Submission No.			121		
Organisation Name or Name of Submitter			Iarnród Éireann		
Item No.	Section Ref.	Page No.	Observation Statement	TII Response	
IÉ Observations (for submission to ABP) relating to MetroLink Railway Order application - 11 th January 2023					
1	Cover letter - IE Observations	1	While land required for the purposes of transport services may be included in a Compulsory Purchase Order application, Section 130 of the Transport Act 1944 precludes the compulsory acquisition of such land without the previous consent of the Minister for Transport.	TII agree with the interpretation of Section 130 of the Transport Act 1944 which as correctly stated precludes the compulsory acquisition of such land without the previous consent of the Minister for Transport. Accordingly, if the Railway Order is confirmed, and the CPO is granted, no Notice to Treat will be served without Ministerial consent. As is normal practice TII will enter into an agreement with CIE / Irish Rail, at the appropriate time, that addresses and deals with any and all land consideration requirements and which allows for any such consents to be made available on receipt of an Enforceable Railway Order.

DRAWING LEGEND	
	EXISTING GSWR UP PROFILE
	EXISTING GSWR DOWN PROFILE
	PROPOSED GSWR UP PROFILE
	PROPOSED GSWR DOWN PROFILE

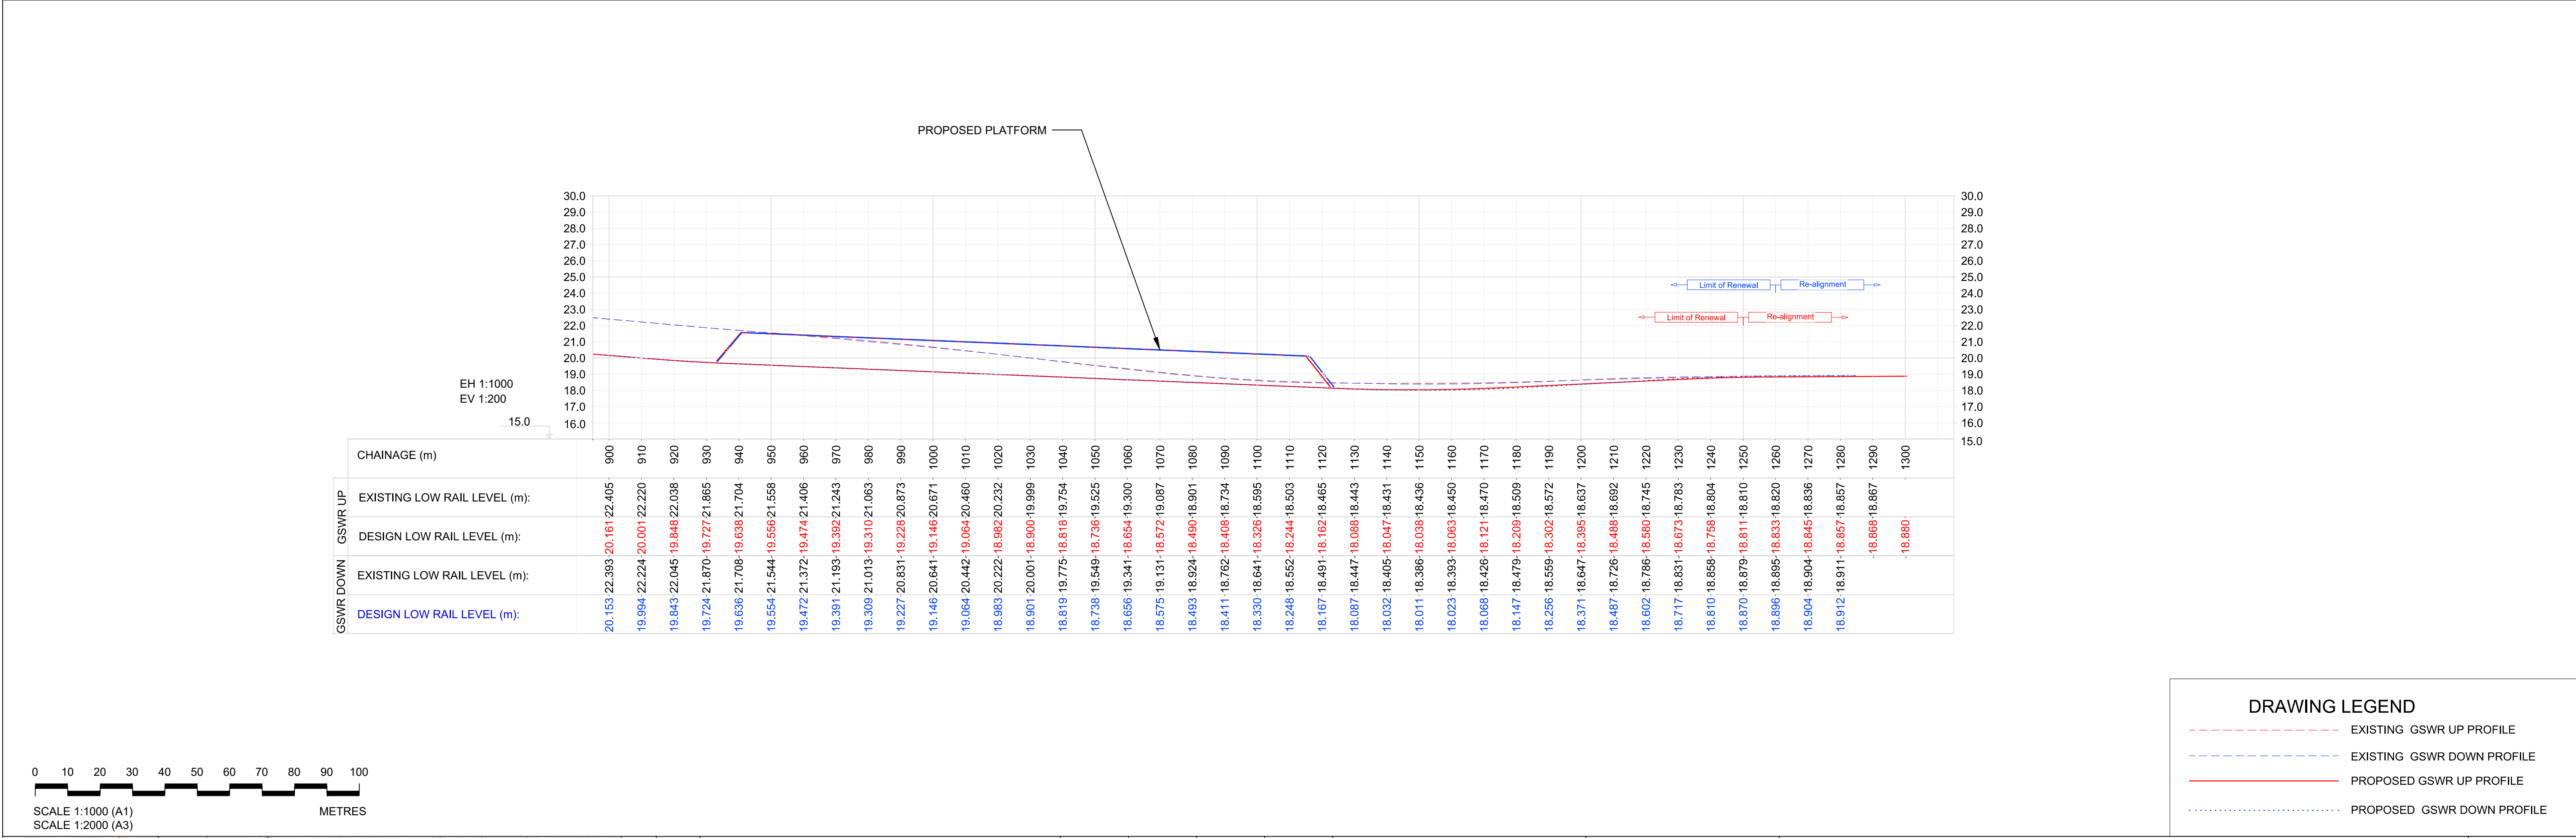
3	Glasnevin Station 1	1	1. While it is understood that Metrolink construction will be impactful on Iarnród Éireann services and our customers, every effort must be made to minimise those impacts. The prolonged closures of the MGWR and GSWR lines proposed by TII at Glasnevin, of 21 and 5 months respectively, to allow the construction of the Glasnevin Station for Metrolink will cause significant disruption to Iarnród Éireann passenger, freight and maintenance services.	The works at Glasnevin are extremely complicated and will require a coordinated approach to ensure successful delivery, particularly given the physical constraints associated with the railway, the canal and fronting residential properties. TII has developed a plan that incorporates a possession regime based on the preliminary design and programme assumptions which were discussed in detail over a number of years with both Iarnród Éireann and the National Transport Authority. The plan is designed to ensure that the works can be delivered safely and efficiently. TII does acknowledge that the plan will lead to disruption of the existing services and will impact on customers. However, TII believe that the planned closures described in the EIAR Chapter 5, MetroLink Construction Phase, Section 5.10.6 and Appendix 5.5 – Glasnevin Station Construction Report, which are 21 months for the Western Commuter Line (Maynooth to Docklands) Midland Great Western Railway (MGWR), and 5 months for the Southwestern Commuter Line, Great Southern and Western Railway (GSWR), represent a worst case construction and customer service impact. TII have been working closely with Iarnród Éireann and the National Transport Authority with a view to reducing the overall duration and impact of the required mainline rail closures, and confirms that every effort will be made to minimise the impacts on the passengers services, especially connection to Connolly station. It is worth noting that during the works taking place on MGWR all trains can still travel to Connolly Station. In both circumstances there will be a number of temporary closures occurring at night-time and weekends fo facilitate track lowering work. TII welcome further discussions with Iarnród Éireann to coordinate any requirements to be included in the main works procurement process and Contract with a view to minimising impacts.

4	Glasnevin Station 2	2	2. Iarnród Éireann is firmly of the view that the prolonged closures proposed are excessive and that, coupled with an appropriate short term track possessions regime, significantly shorter closure periods should be feasible. The disruptive impacts to train operations must be minimised and timed for periods of lower passenger and freight usage on Iarnród Éireann services e.g. summer months.	Please refer to Response (3) above.
